KIRKLEES METROPOLITAN COUNCIL INVESTMENT & REGENERATION SERVICE

DELEGATED DECISION TO DETERMINE APPLICATIONS FOR CONSENT, AGREEMENT OR APPROVAL REQUIRED BY CONDITION

Reference No:	2022/44/93608/E
Site Address:	Land adj, High Street and Challenge Way, Hanging Heaton, Batley, WF17 6DP
Description:	Discharge of conditions 24 (Landscape Strategy), 25 (Ventilation Mitigation Strategy), 26 (Secure Cycle Parking), 27 (Lighting Design Strategy for Biodiversity), 28 (Temporary Waste Storage and Collection) and 29 (EVCP) of previous permission 2021/91871 for erection of residential development (55 dwellings) including access and associated infrastructure
Recommending Officer:	Nick Hirst

DECISION – Discharge of Conditions – Approve

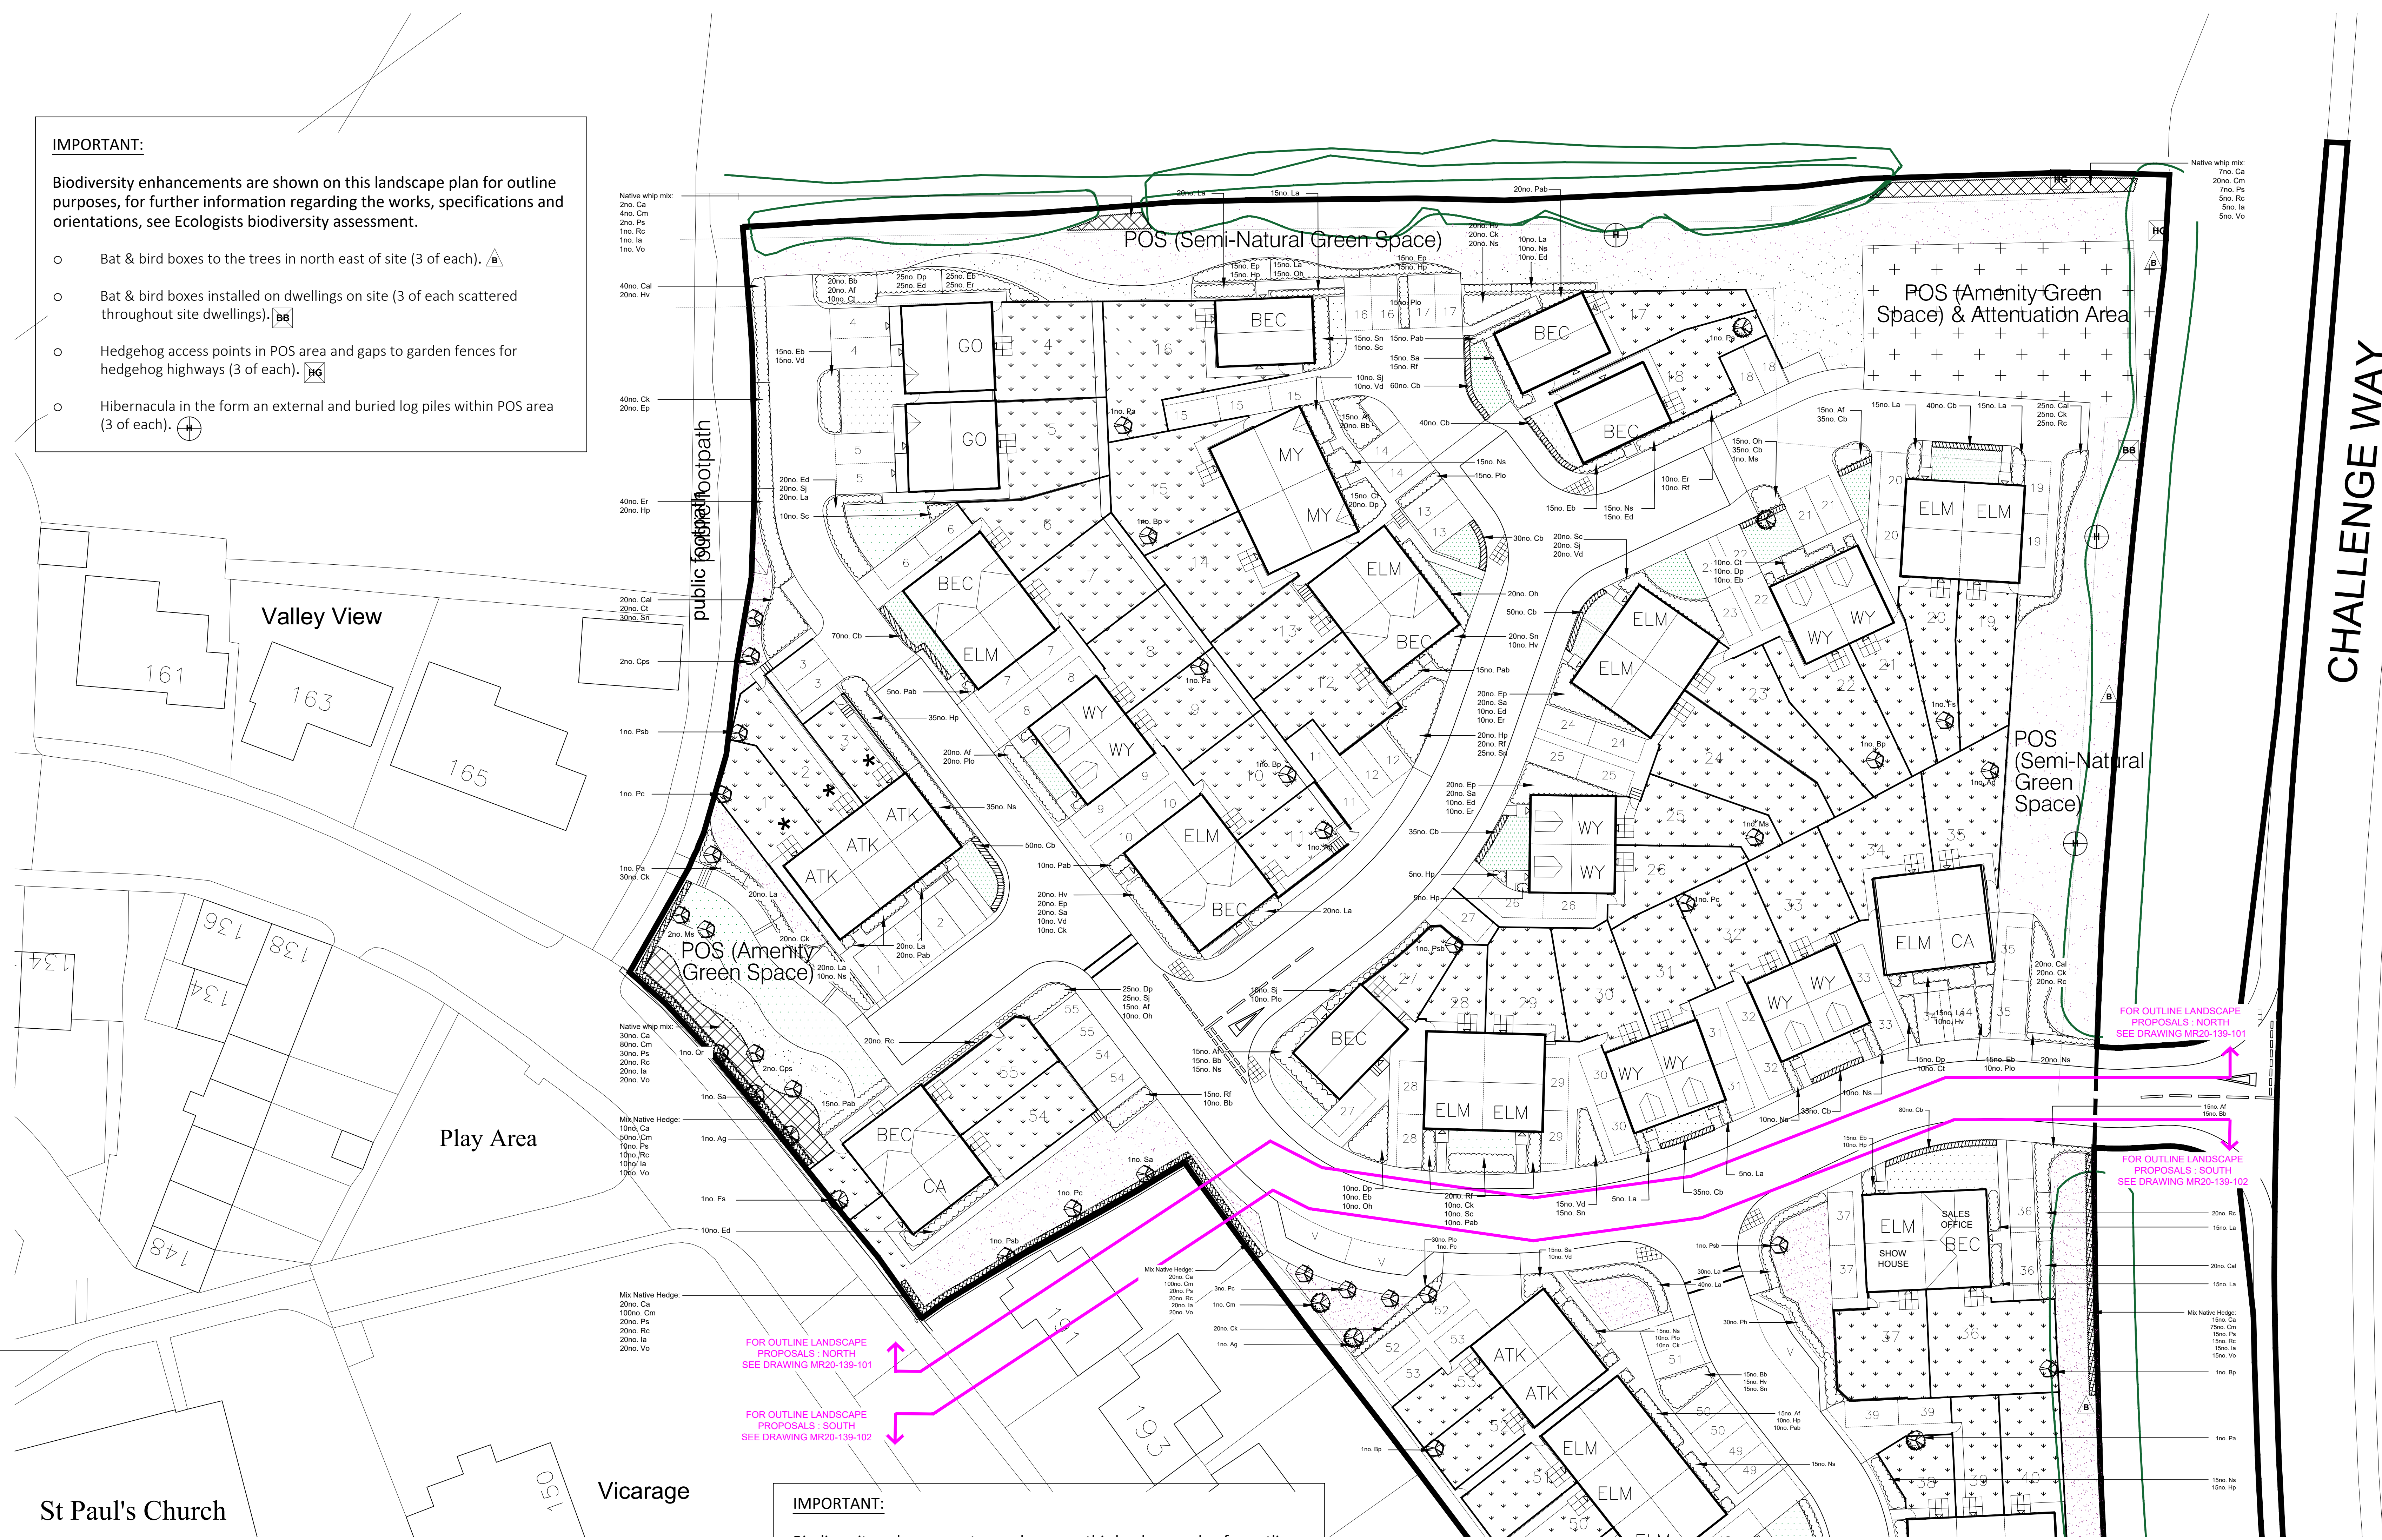
K.C. Landscape expressed concerns over the lack of details on the timeframe for maintenance and the location of trees proposed.

On the matter of the location of trees, officers shared this concern. The majority of trees were proposed within back gardens, where they would have limited public amenity value due to not being visible. This led to an amended plan which repositioned many of the trees to front gardens / verges / open space. As a result, the trees would be more prominently visible and would contribute to an attractive streetscene.

Officers and K.C. landscape consider the final plan to be acceptable. Officers therefore recommend that the details submitted pursuant to condition 24 be approved.

PLANNING CONDITION 26 (2021/91871)

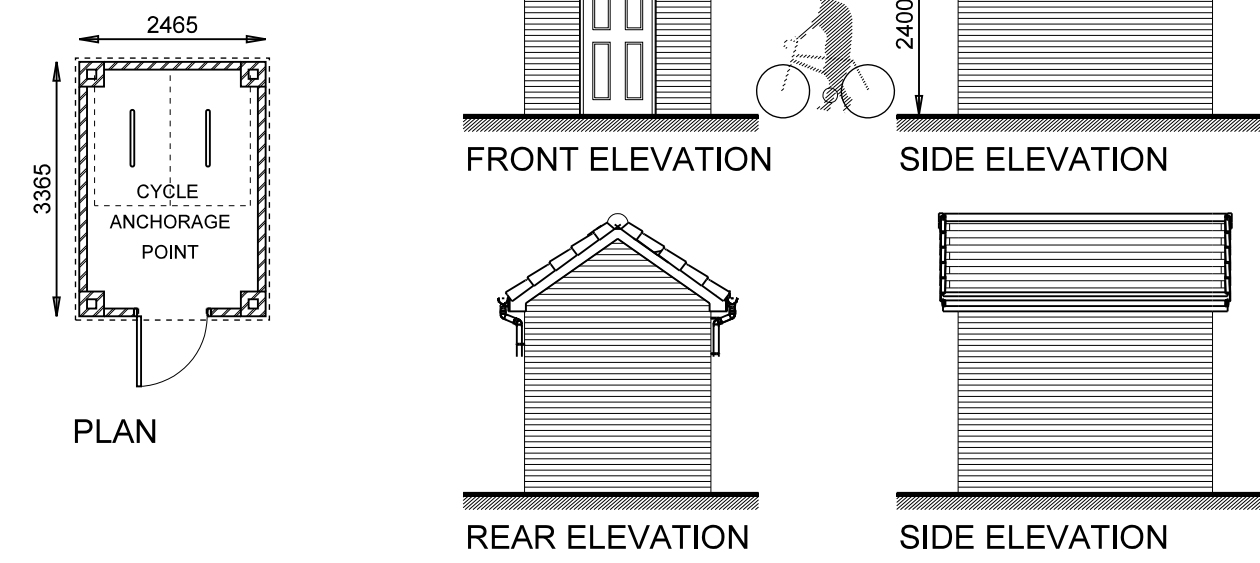
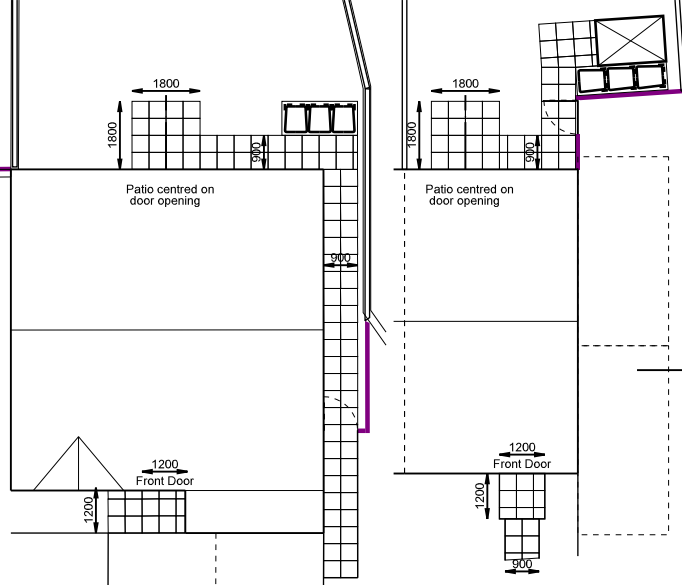
The submitted information was initially considered lacking in detail and security features.

However, officers requested that cycle stores sited above the easement crossing the site be removed (namely at plots 37, 39, 40, 47 – 53 and 55). It is accepted that this results in not all units having a cycle store, however it is considered necessary to prevent conflict with the management and maintenance of the easement (and to conform to condition 36, which secures the easement). No other practical locations for cycle stores on these plots were identified, and cycles would need to be stored within dwellings.

Following feedback and amendments the re-submitted details have been reviewed by the West Yorkshire Police Designing Out Crime Officer and found to be acceptable from a security perspective. The storage details were also considered acceptable to officers, being both secure and of a sufficient quality to promote cycle usage.
